From: Michael Eastham <Michael.Eastham@arun.gov.uk>
Sent: 15 May 2020 11:03
To: Planning.Responses <Planning.Responses@arun.gov.uk>
Subject: FW: Planning Consultation on BE/21/20/DOC - Salt Box

Subject: RE: Planning Consultation on BE/21/20/DOC

APPLICATION NO: BE/21/20/DOC

Site Address: Land At Salt Box West Of Shripney Road Bognor Regis PO22 9NW

SECTION 1-1
CROSS SECTION THROUGH AT-401
SCALE 1:25
(REFER TO C-7010 FOR LOCATION)

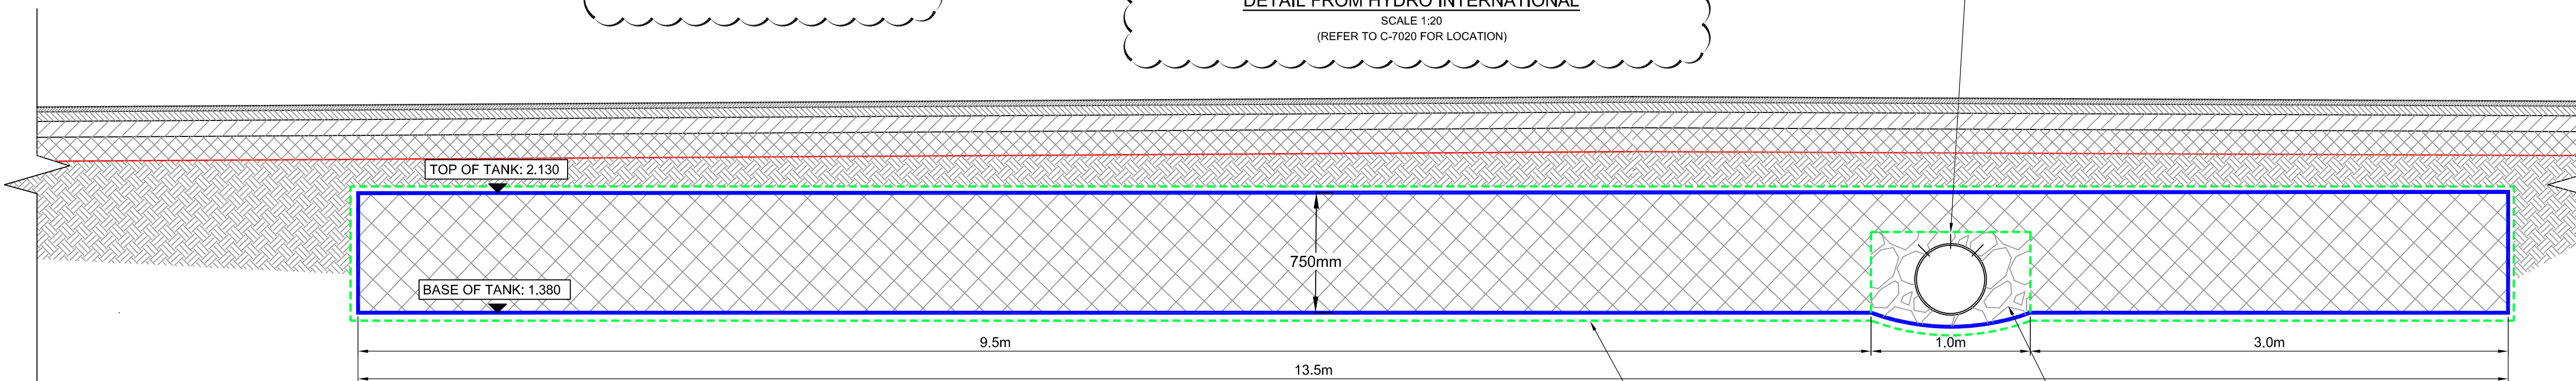
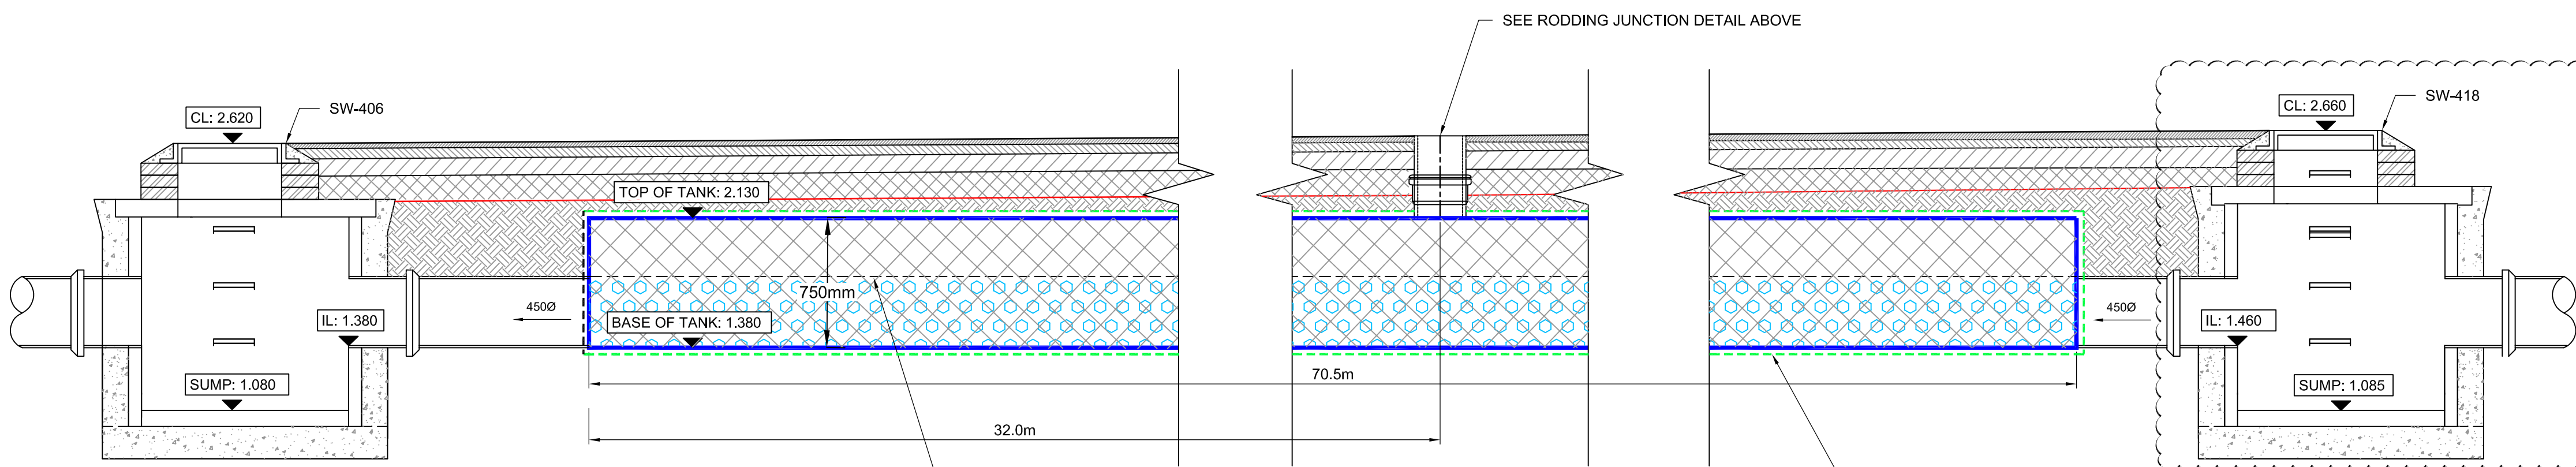
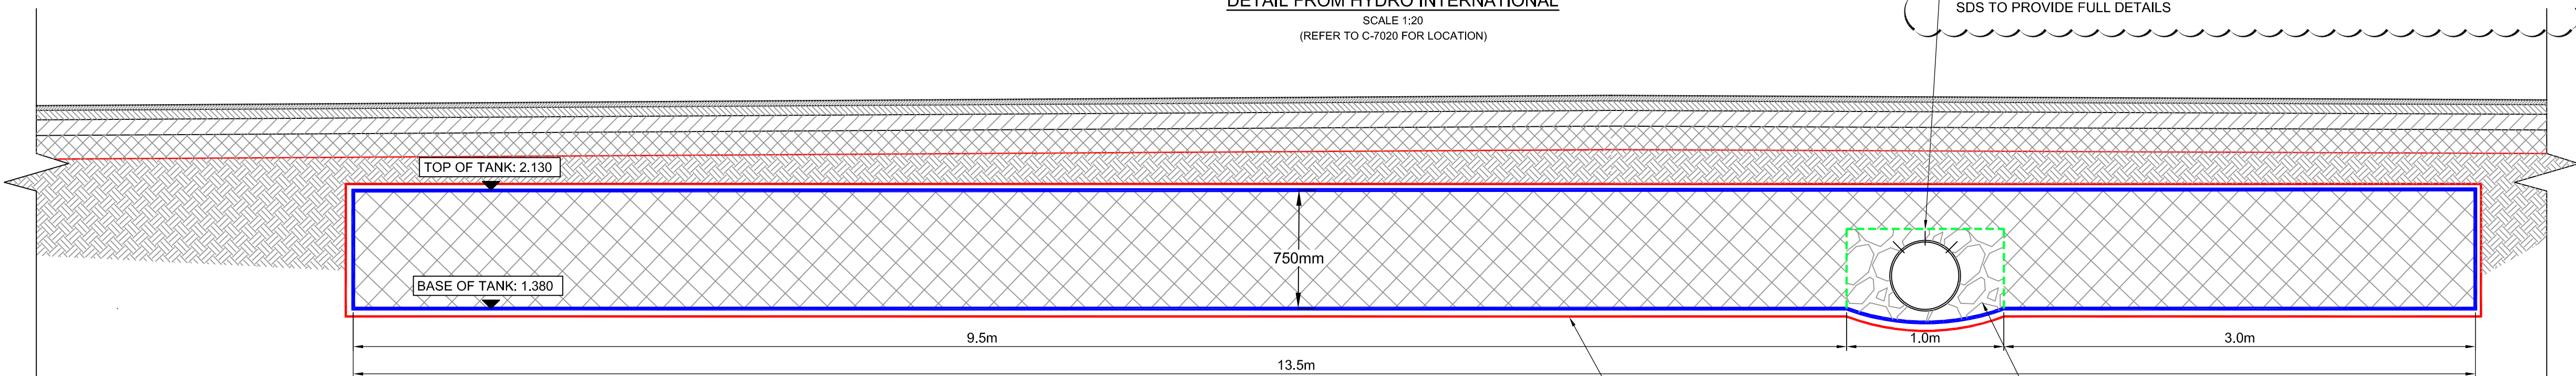
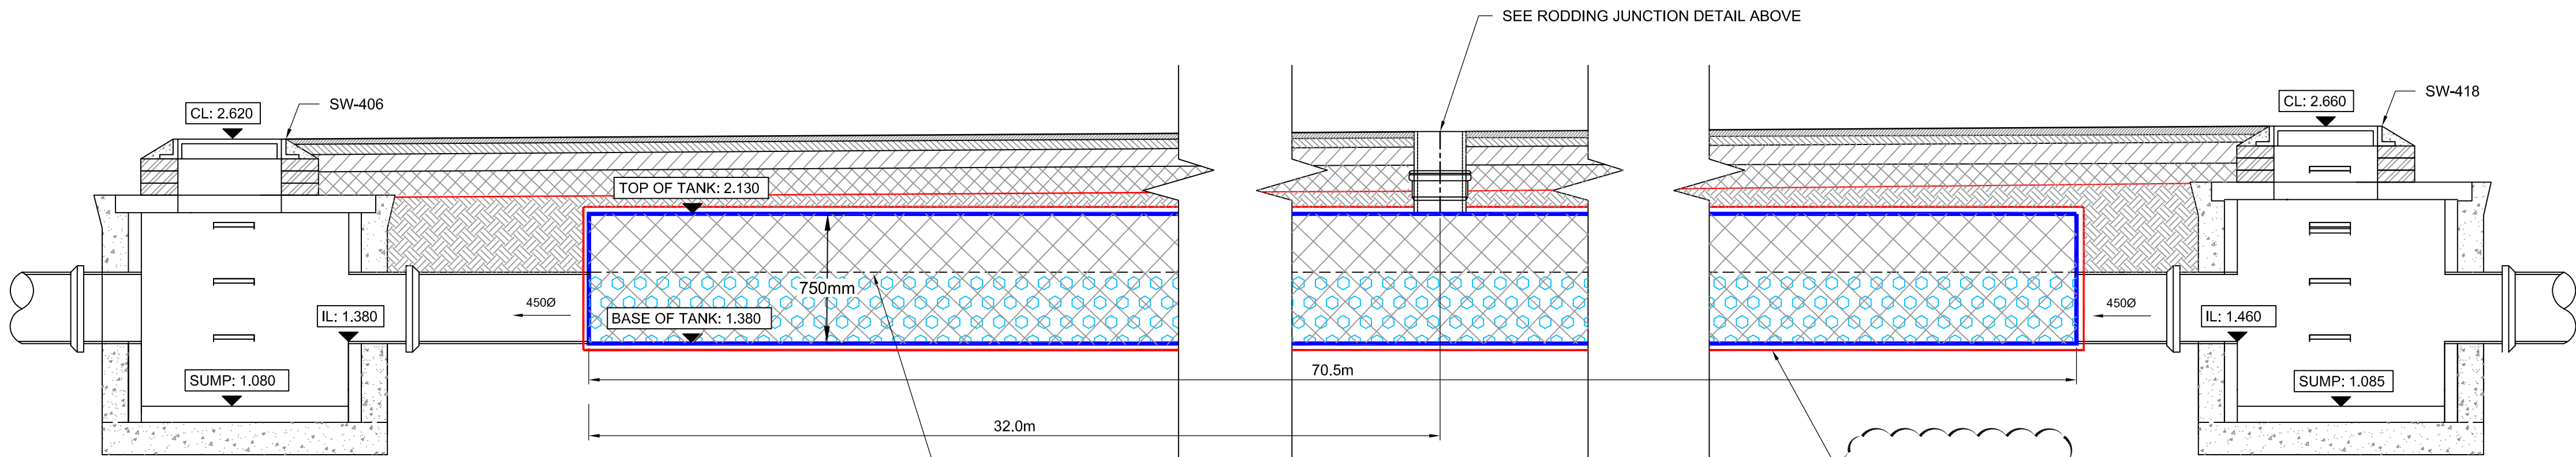
15. Drawing 7010 - SW-405 to tank – specify pipe diameter and a reasonable gradient.
Gradient added ok
16. Drawing 7103 (Phase 2)– Section 2-2 – should this be labelled AT-401?
401 label added. ok

17. Drawings 7103 (Phase 1 & 2) ie. AT-201 and AT-401 – specify granular surround to pipe including thickness. Provide permeable geotextile wrapping to bedding.
Granular material detail note added and permeable textile wrapping note added. Done for AT-401. AT-201 – no drawing supplied?

18. AT-401 – Provide integral catchpit manhole in crates at connecting junction as opposed to a 300mm vertical pipe.
SDS tanks do not have a tank spec that allows for manholes to be installed within the tank but can provide a rodding access similar to what is shown and they allow for junctions in the pipe. ok but T junction access detail needs to refer to AT-401
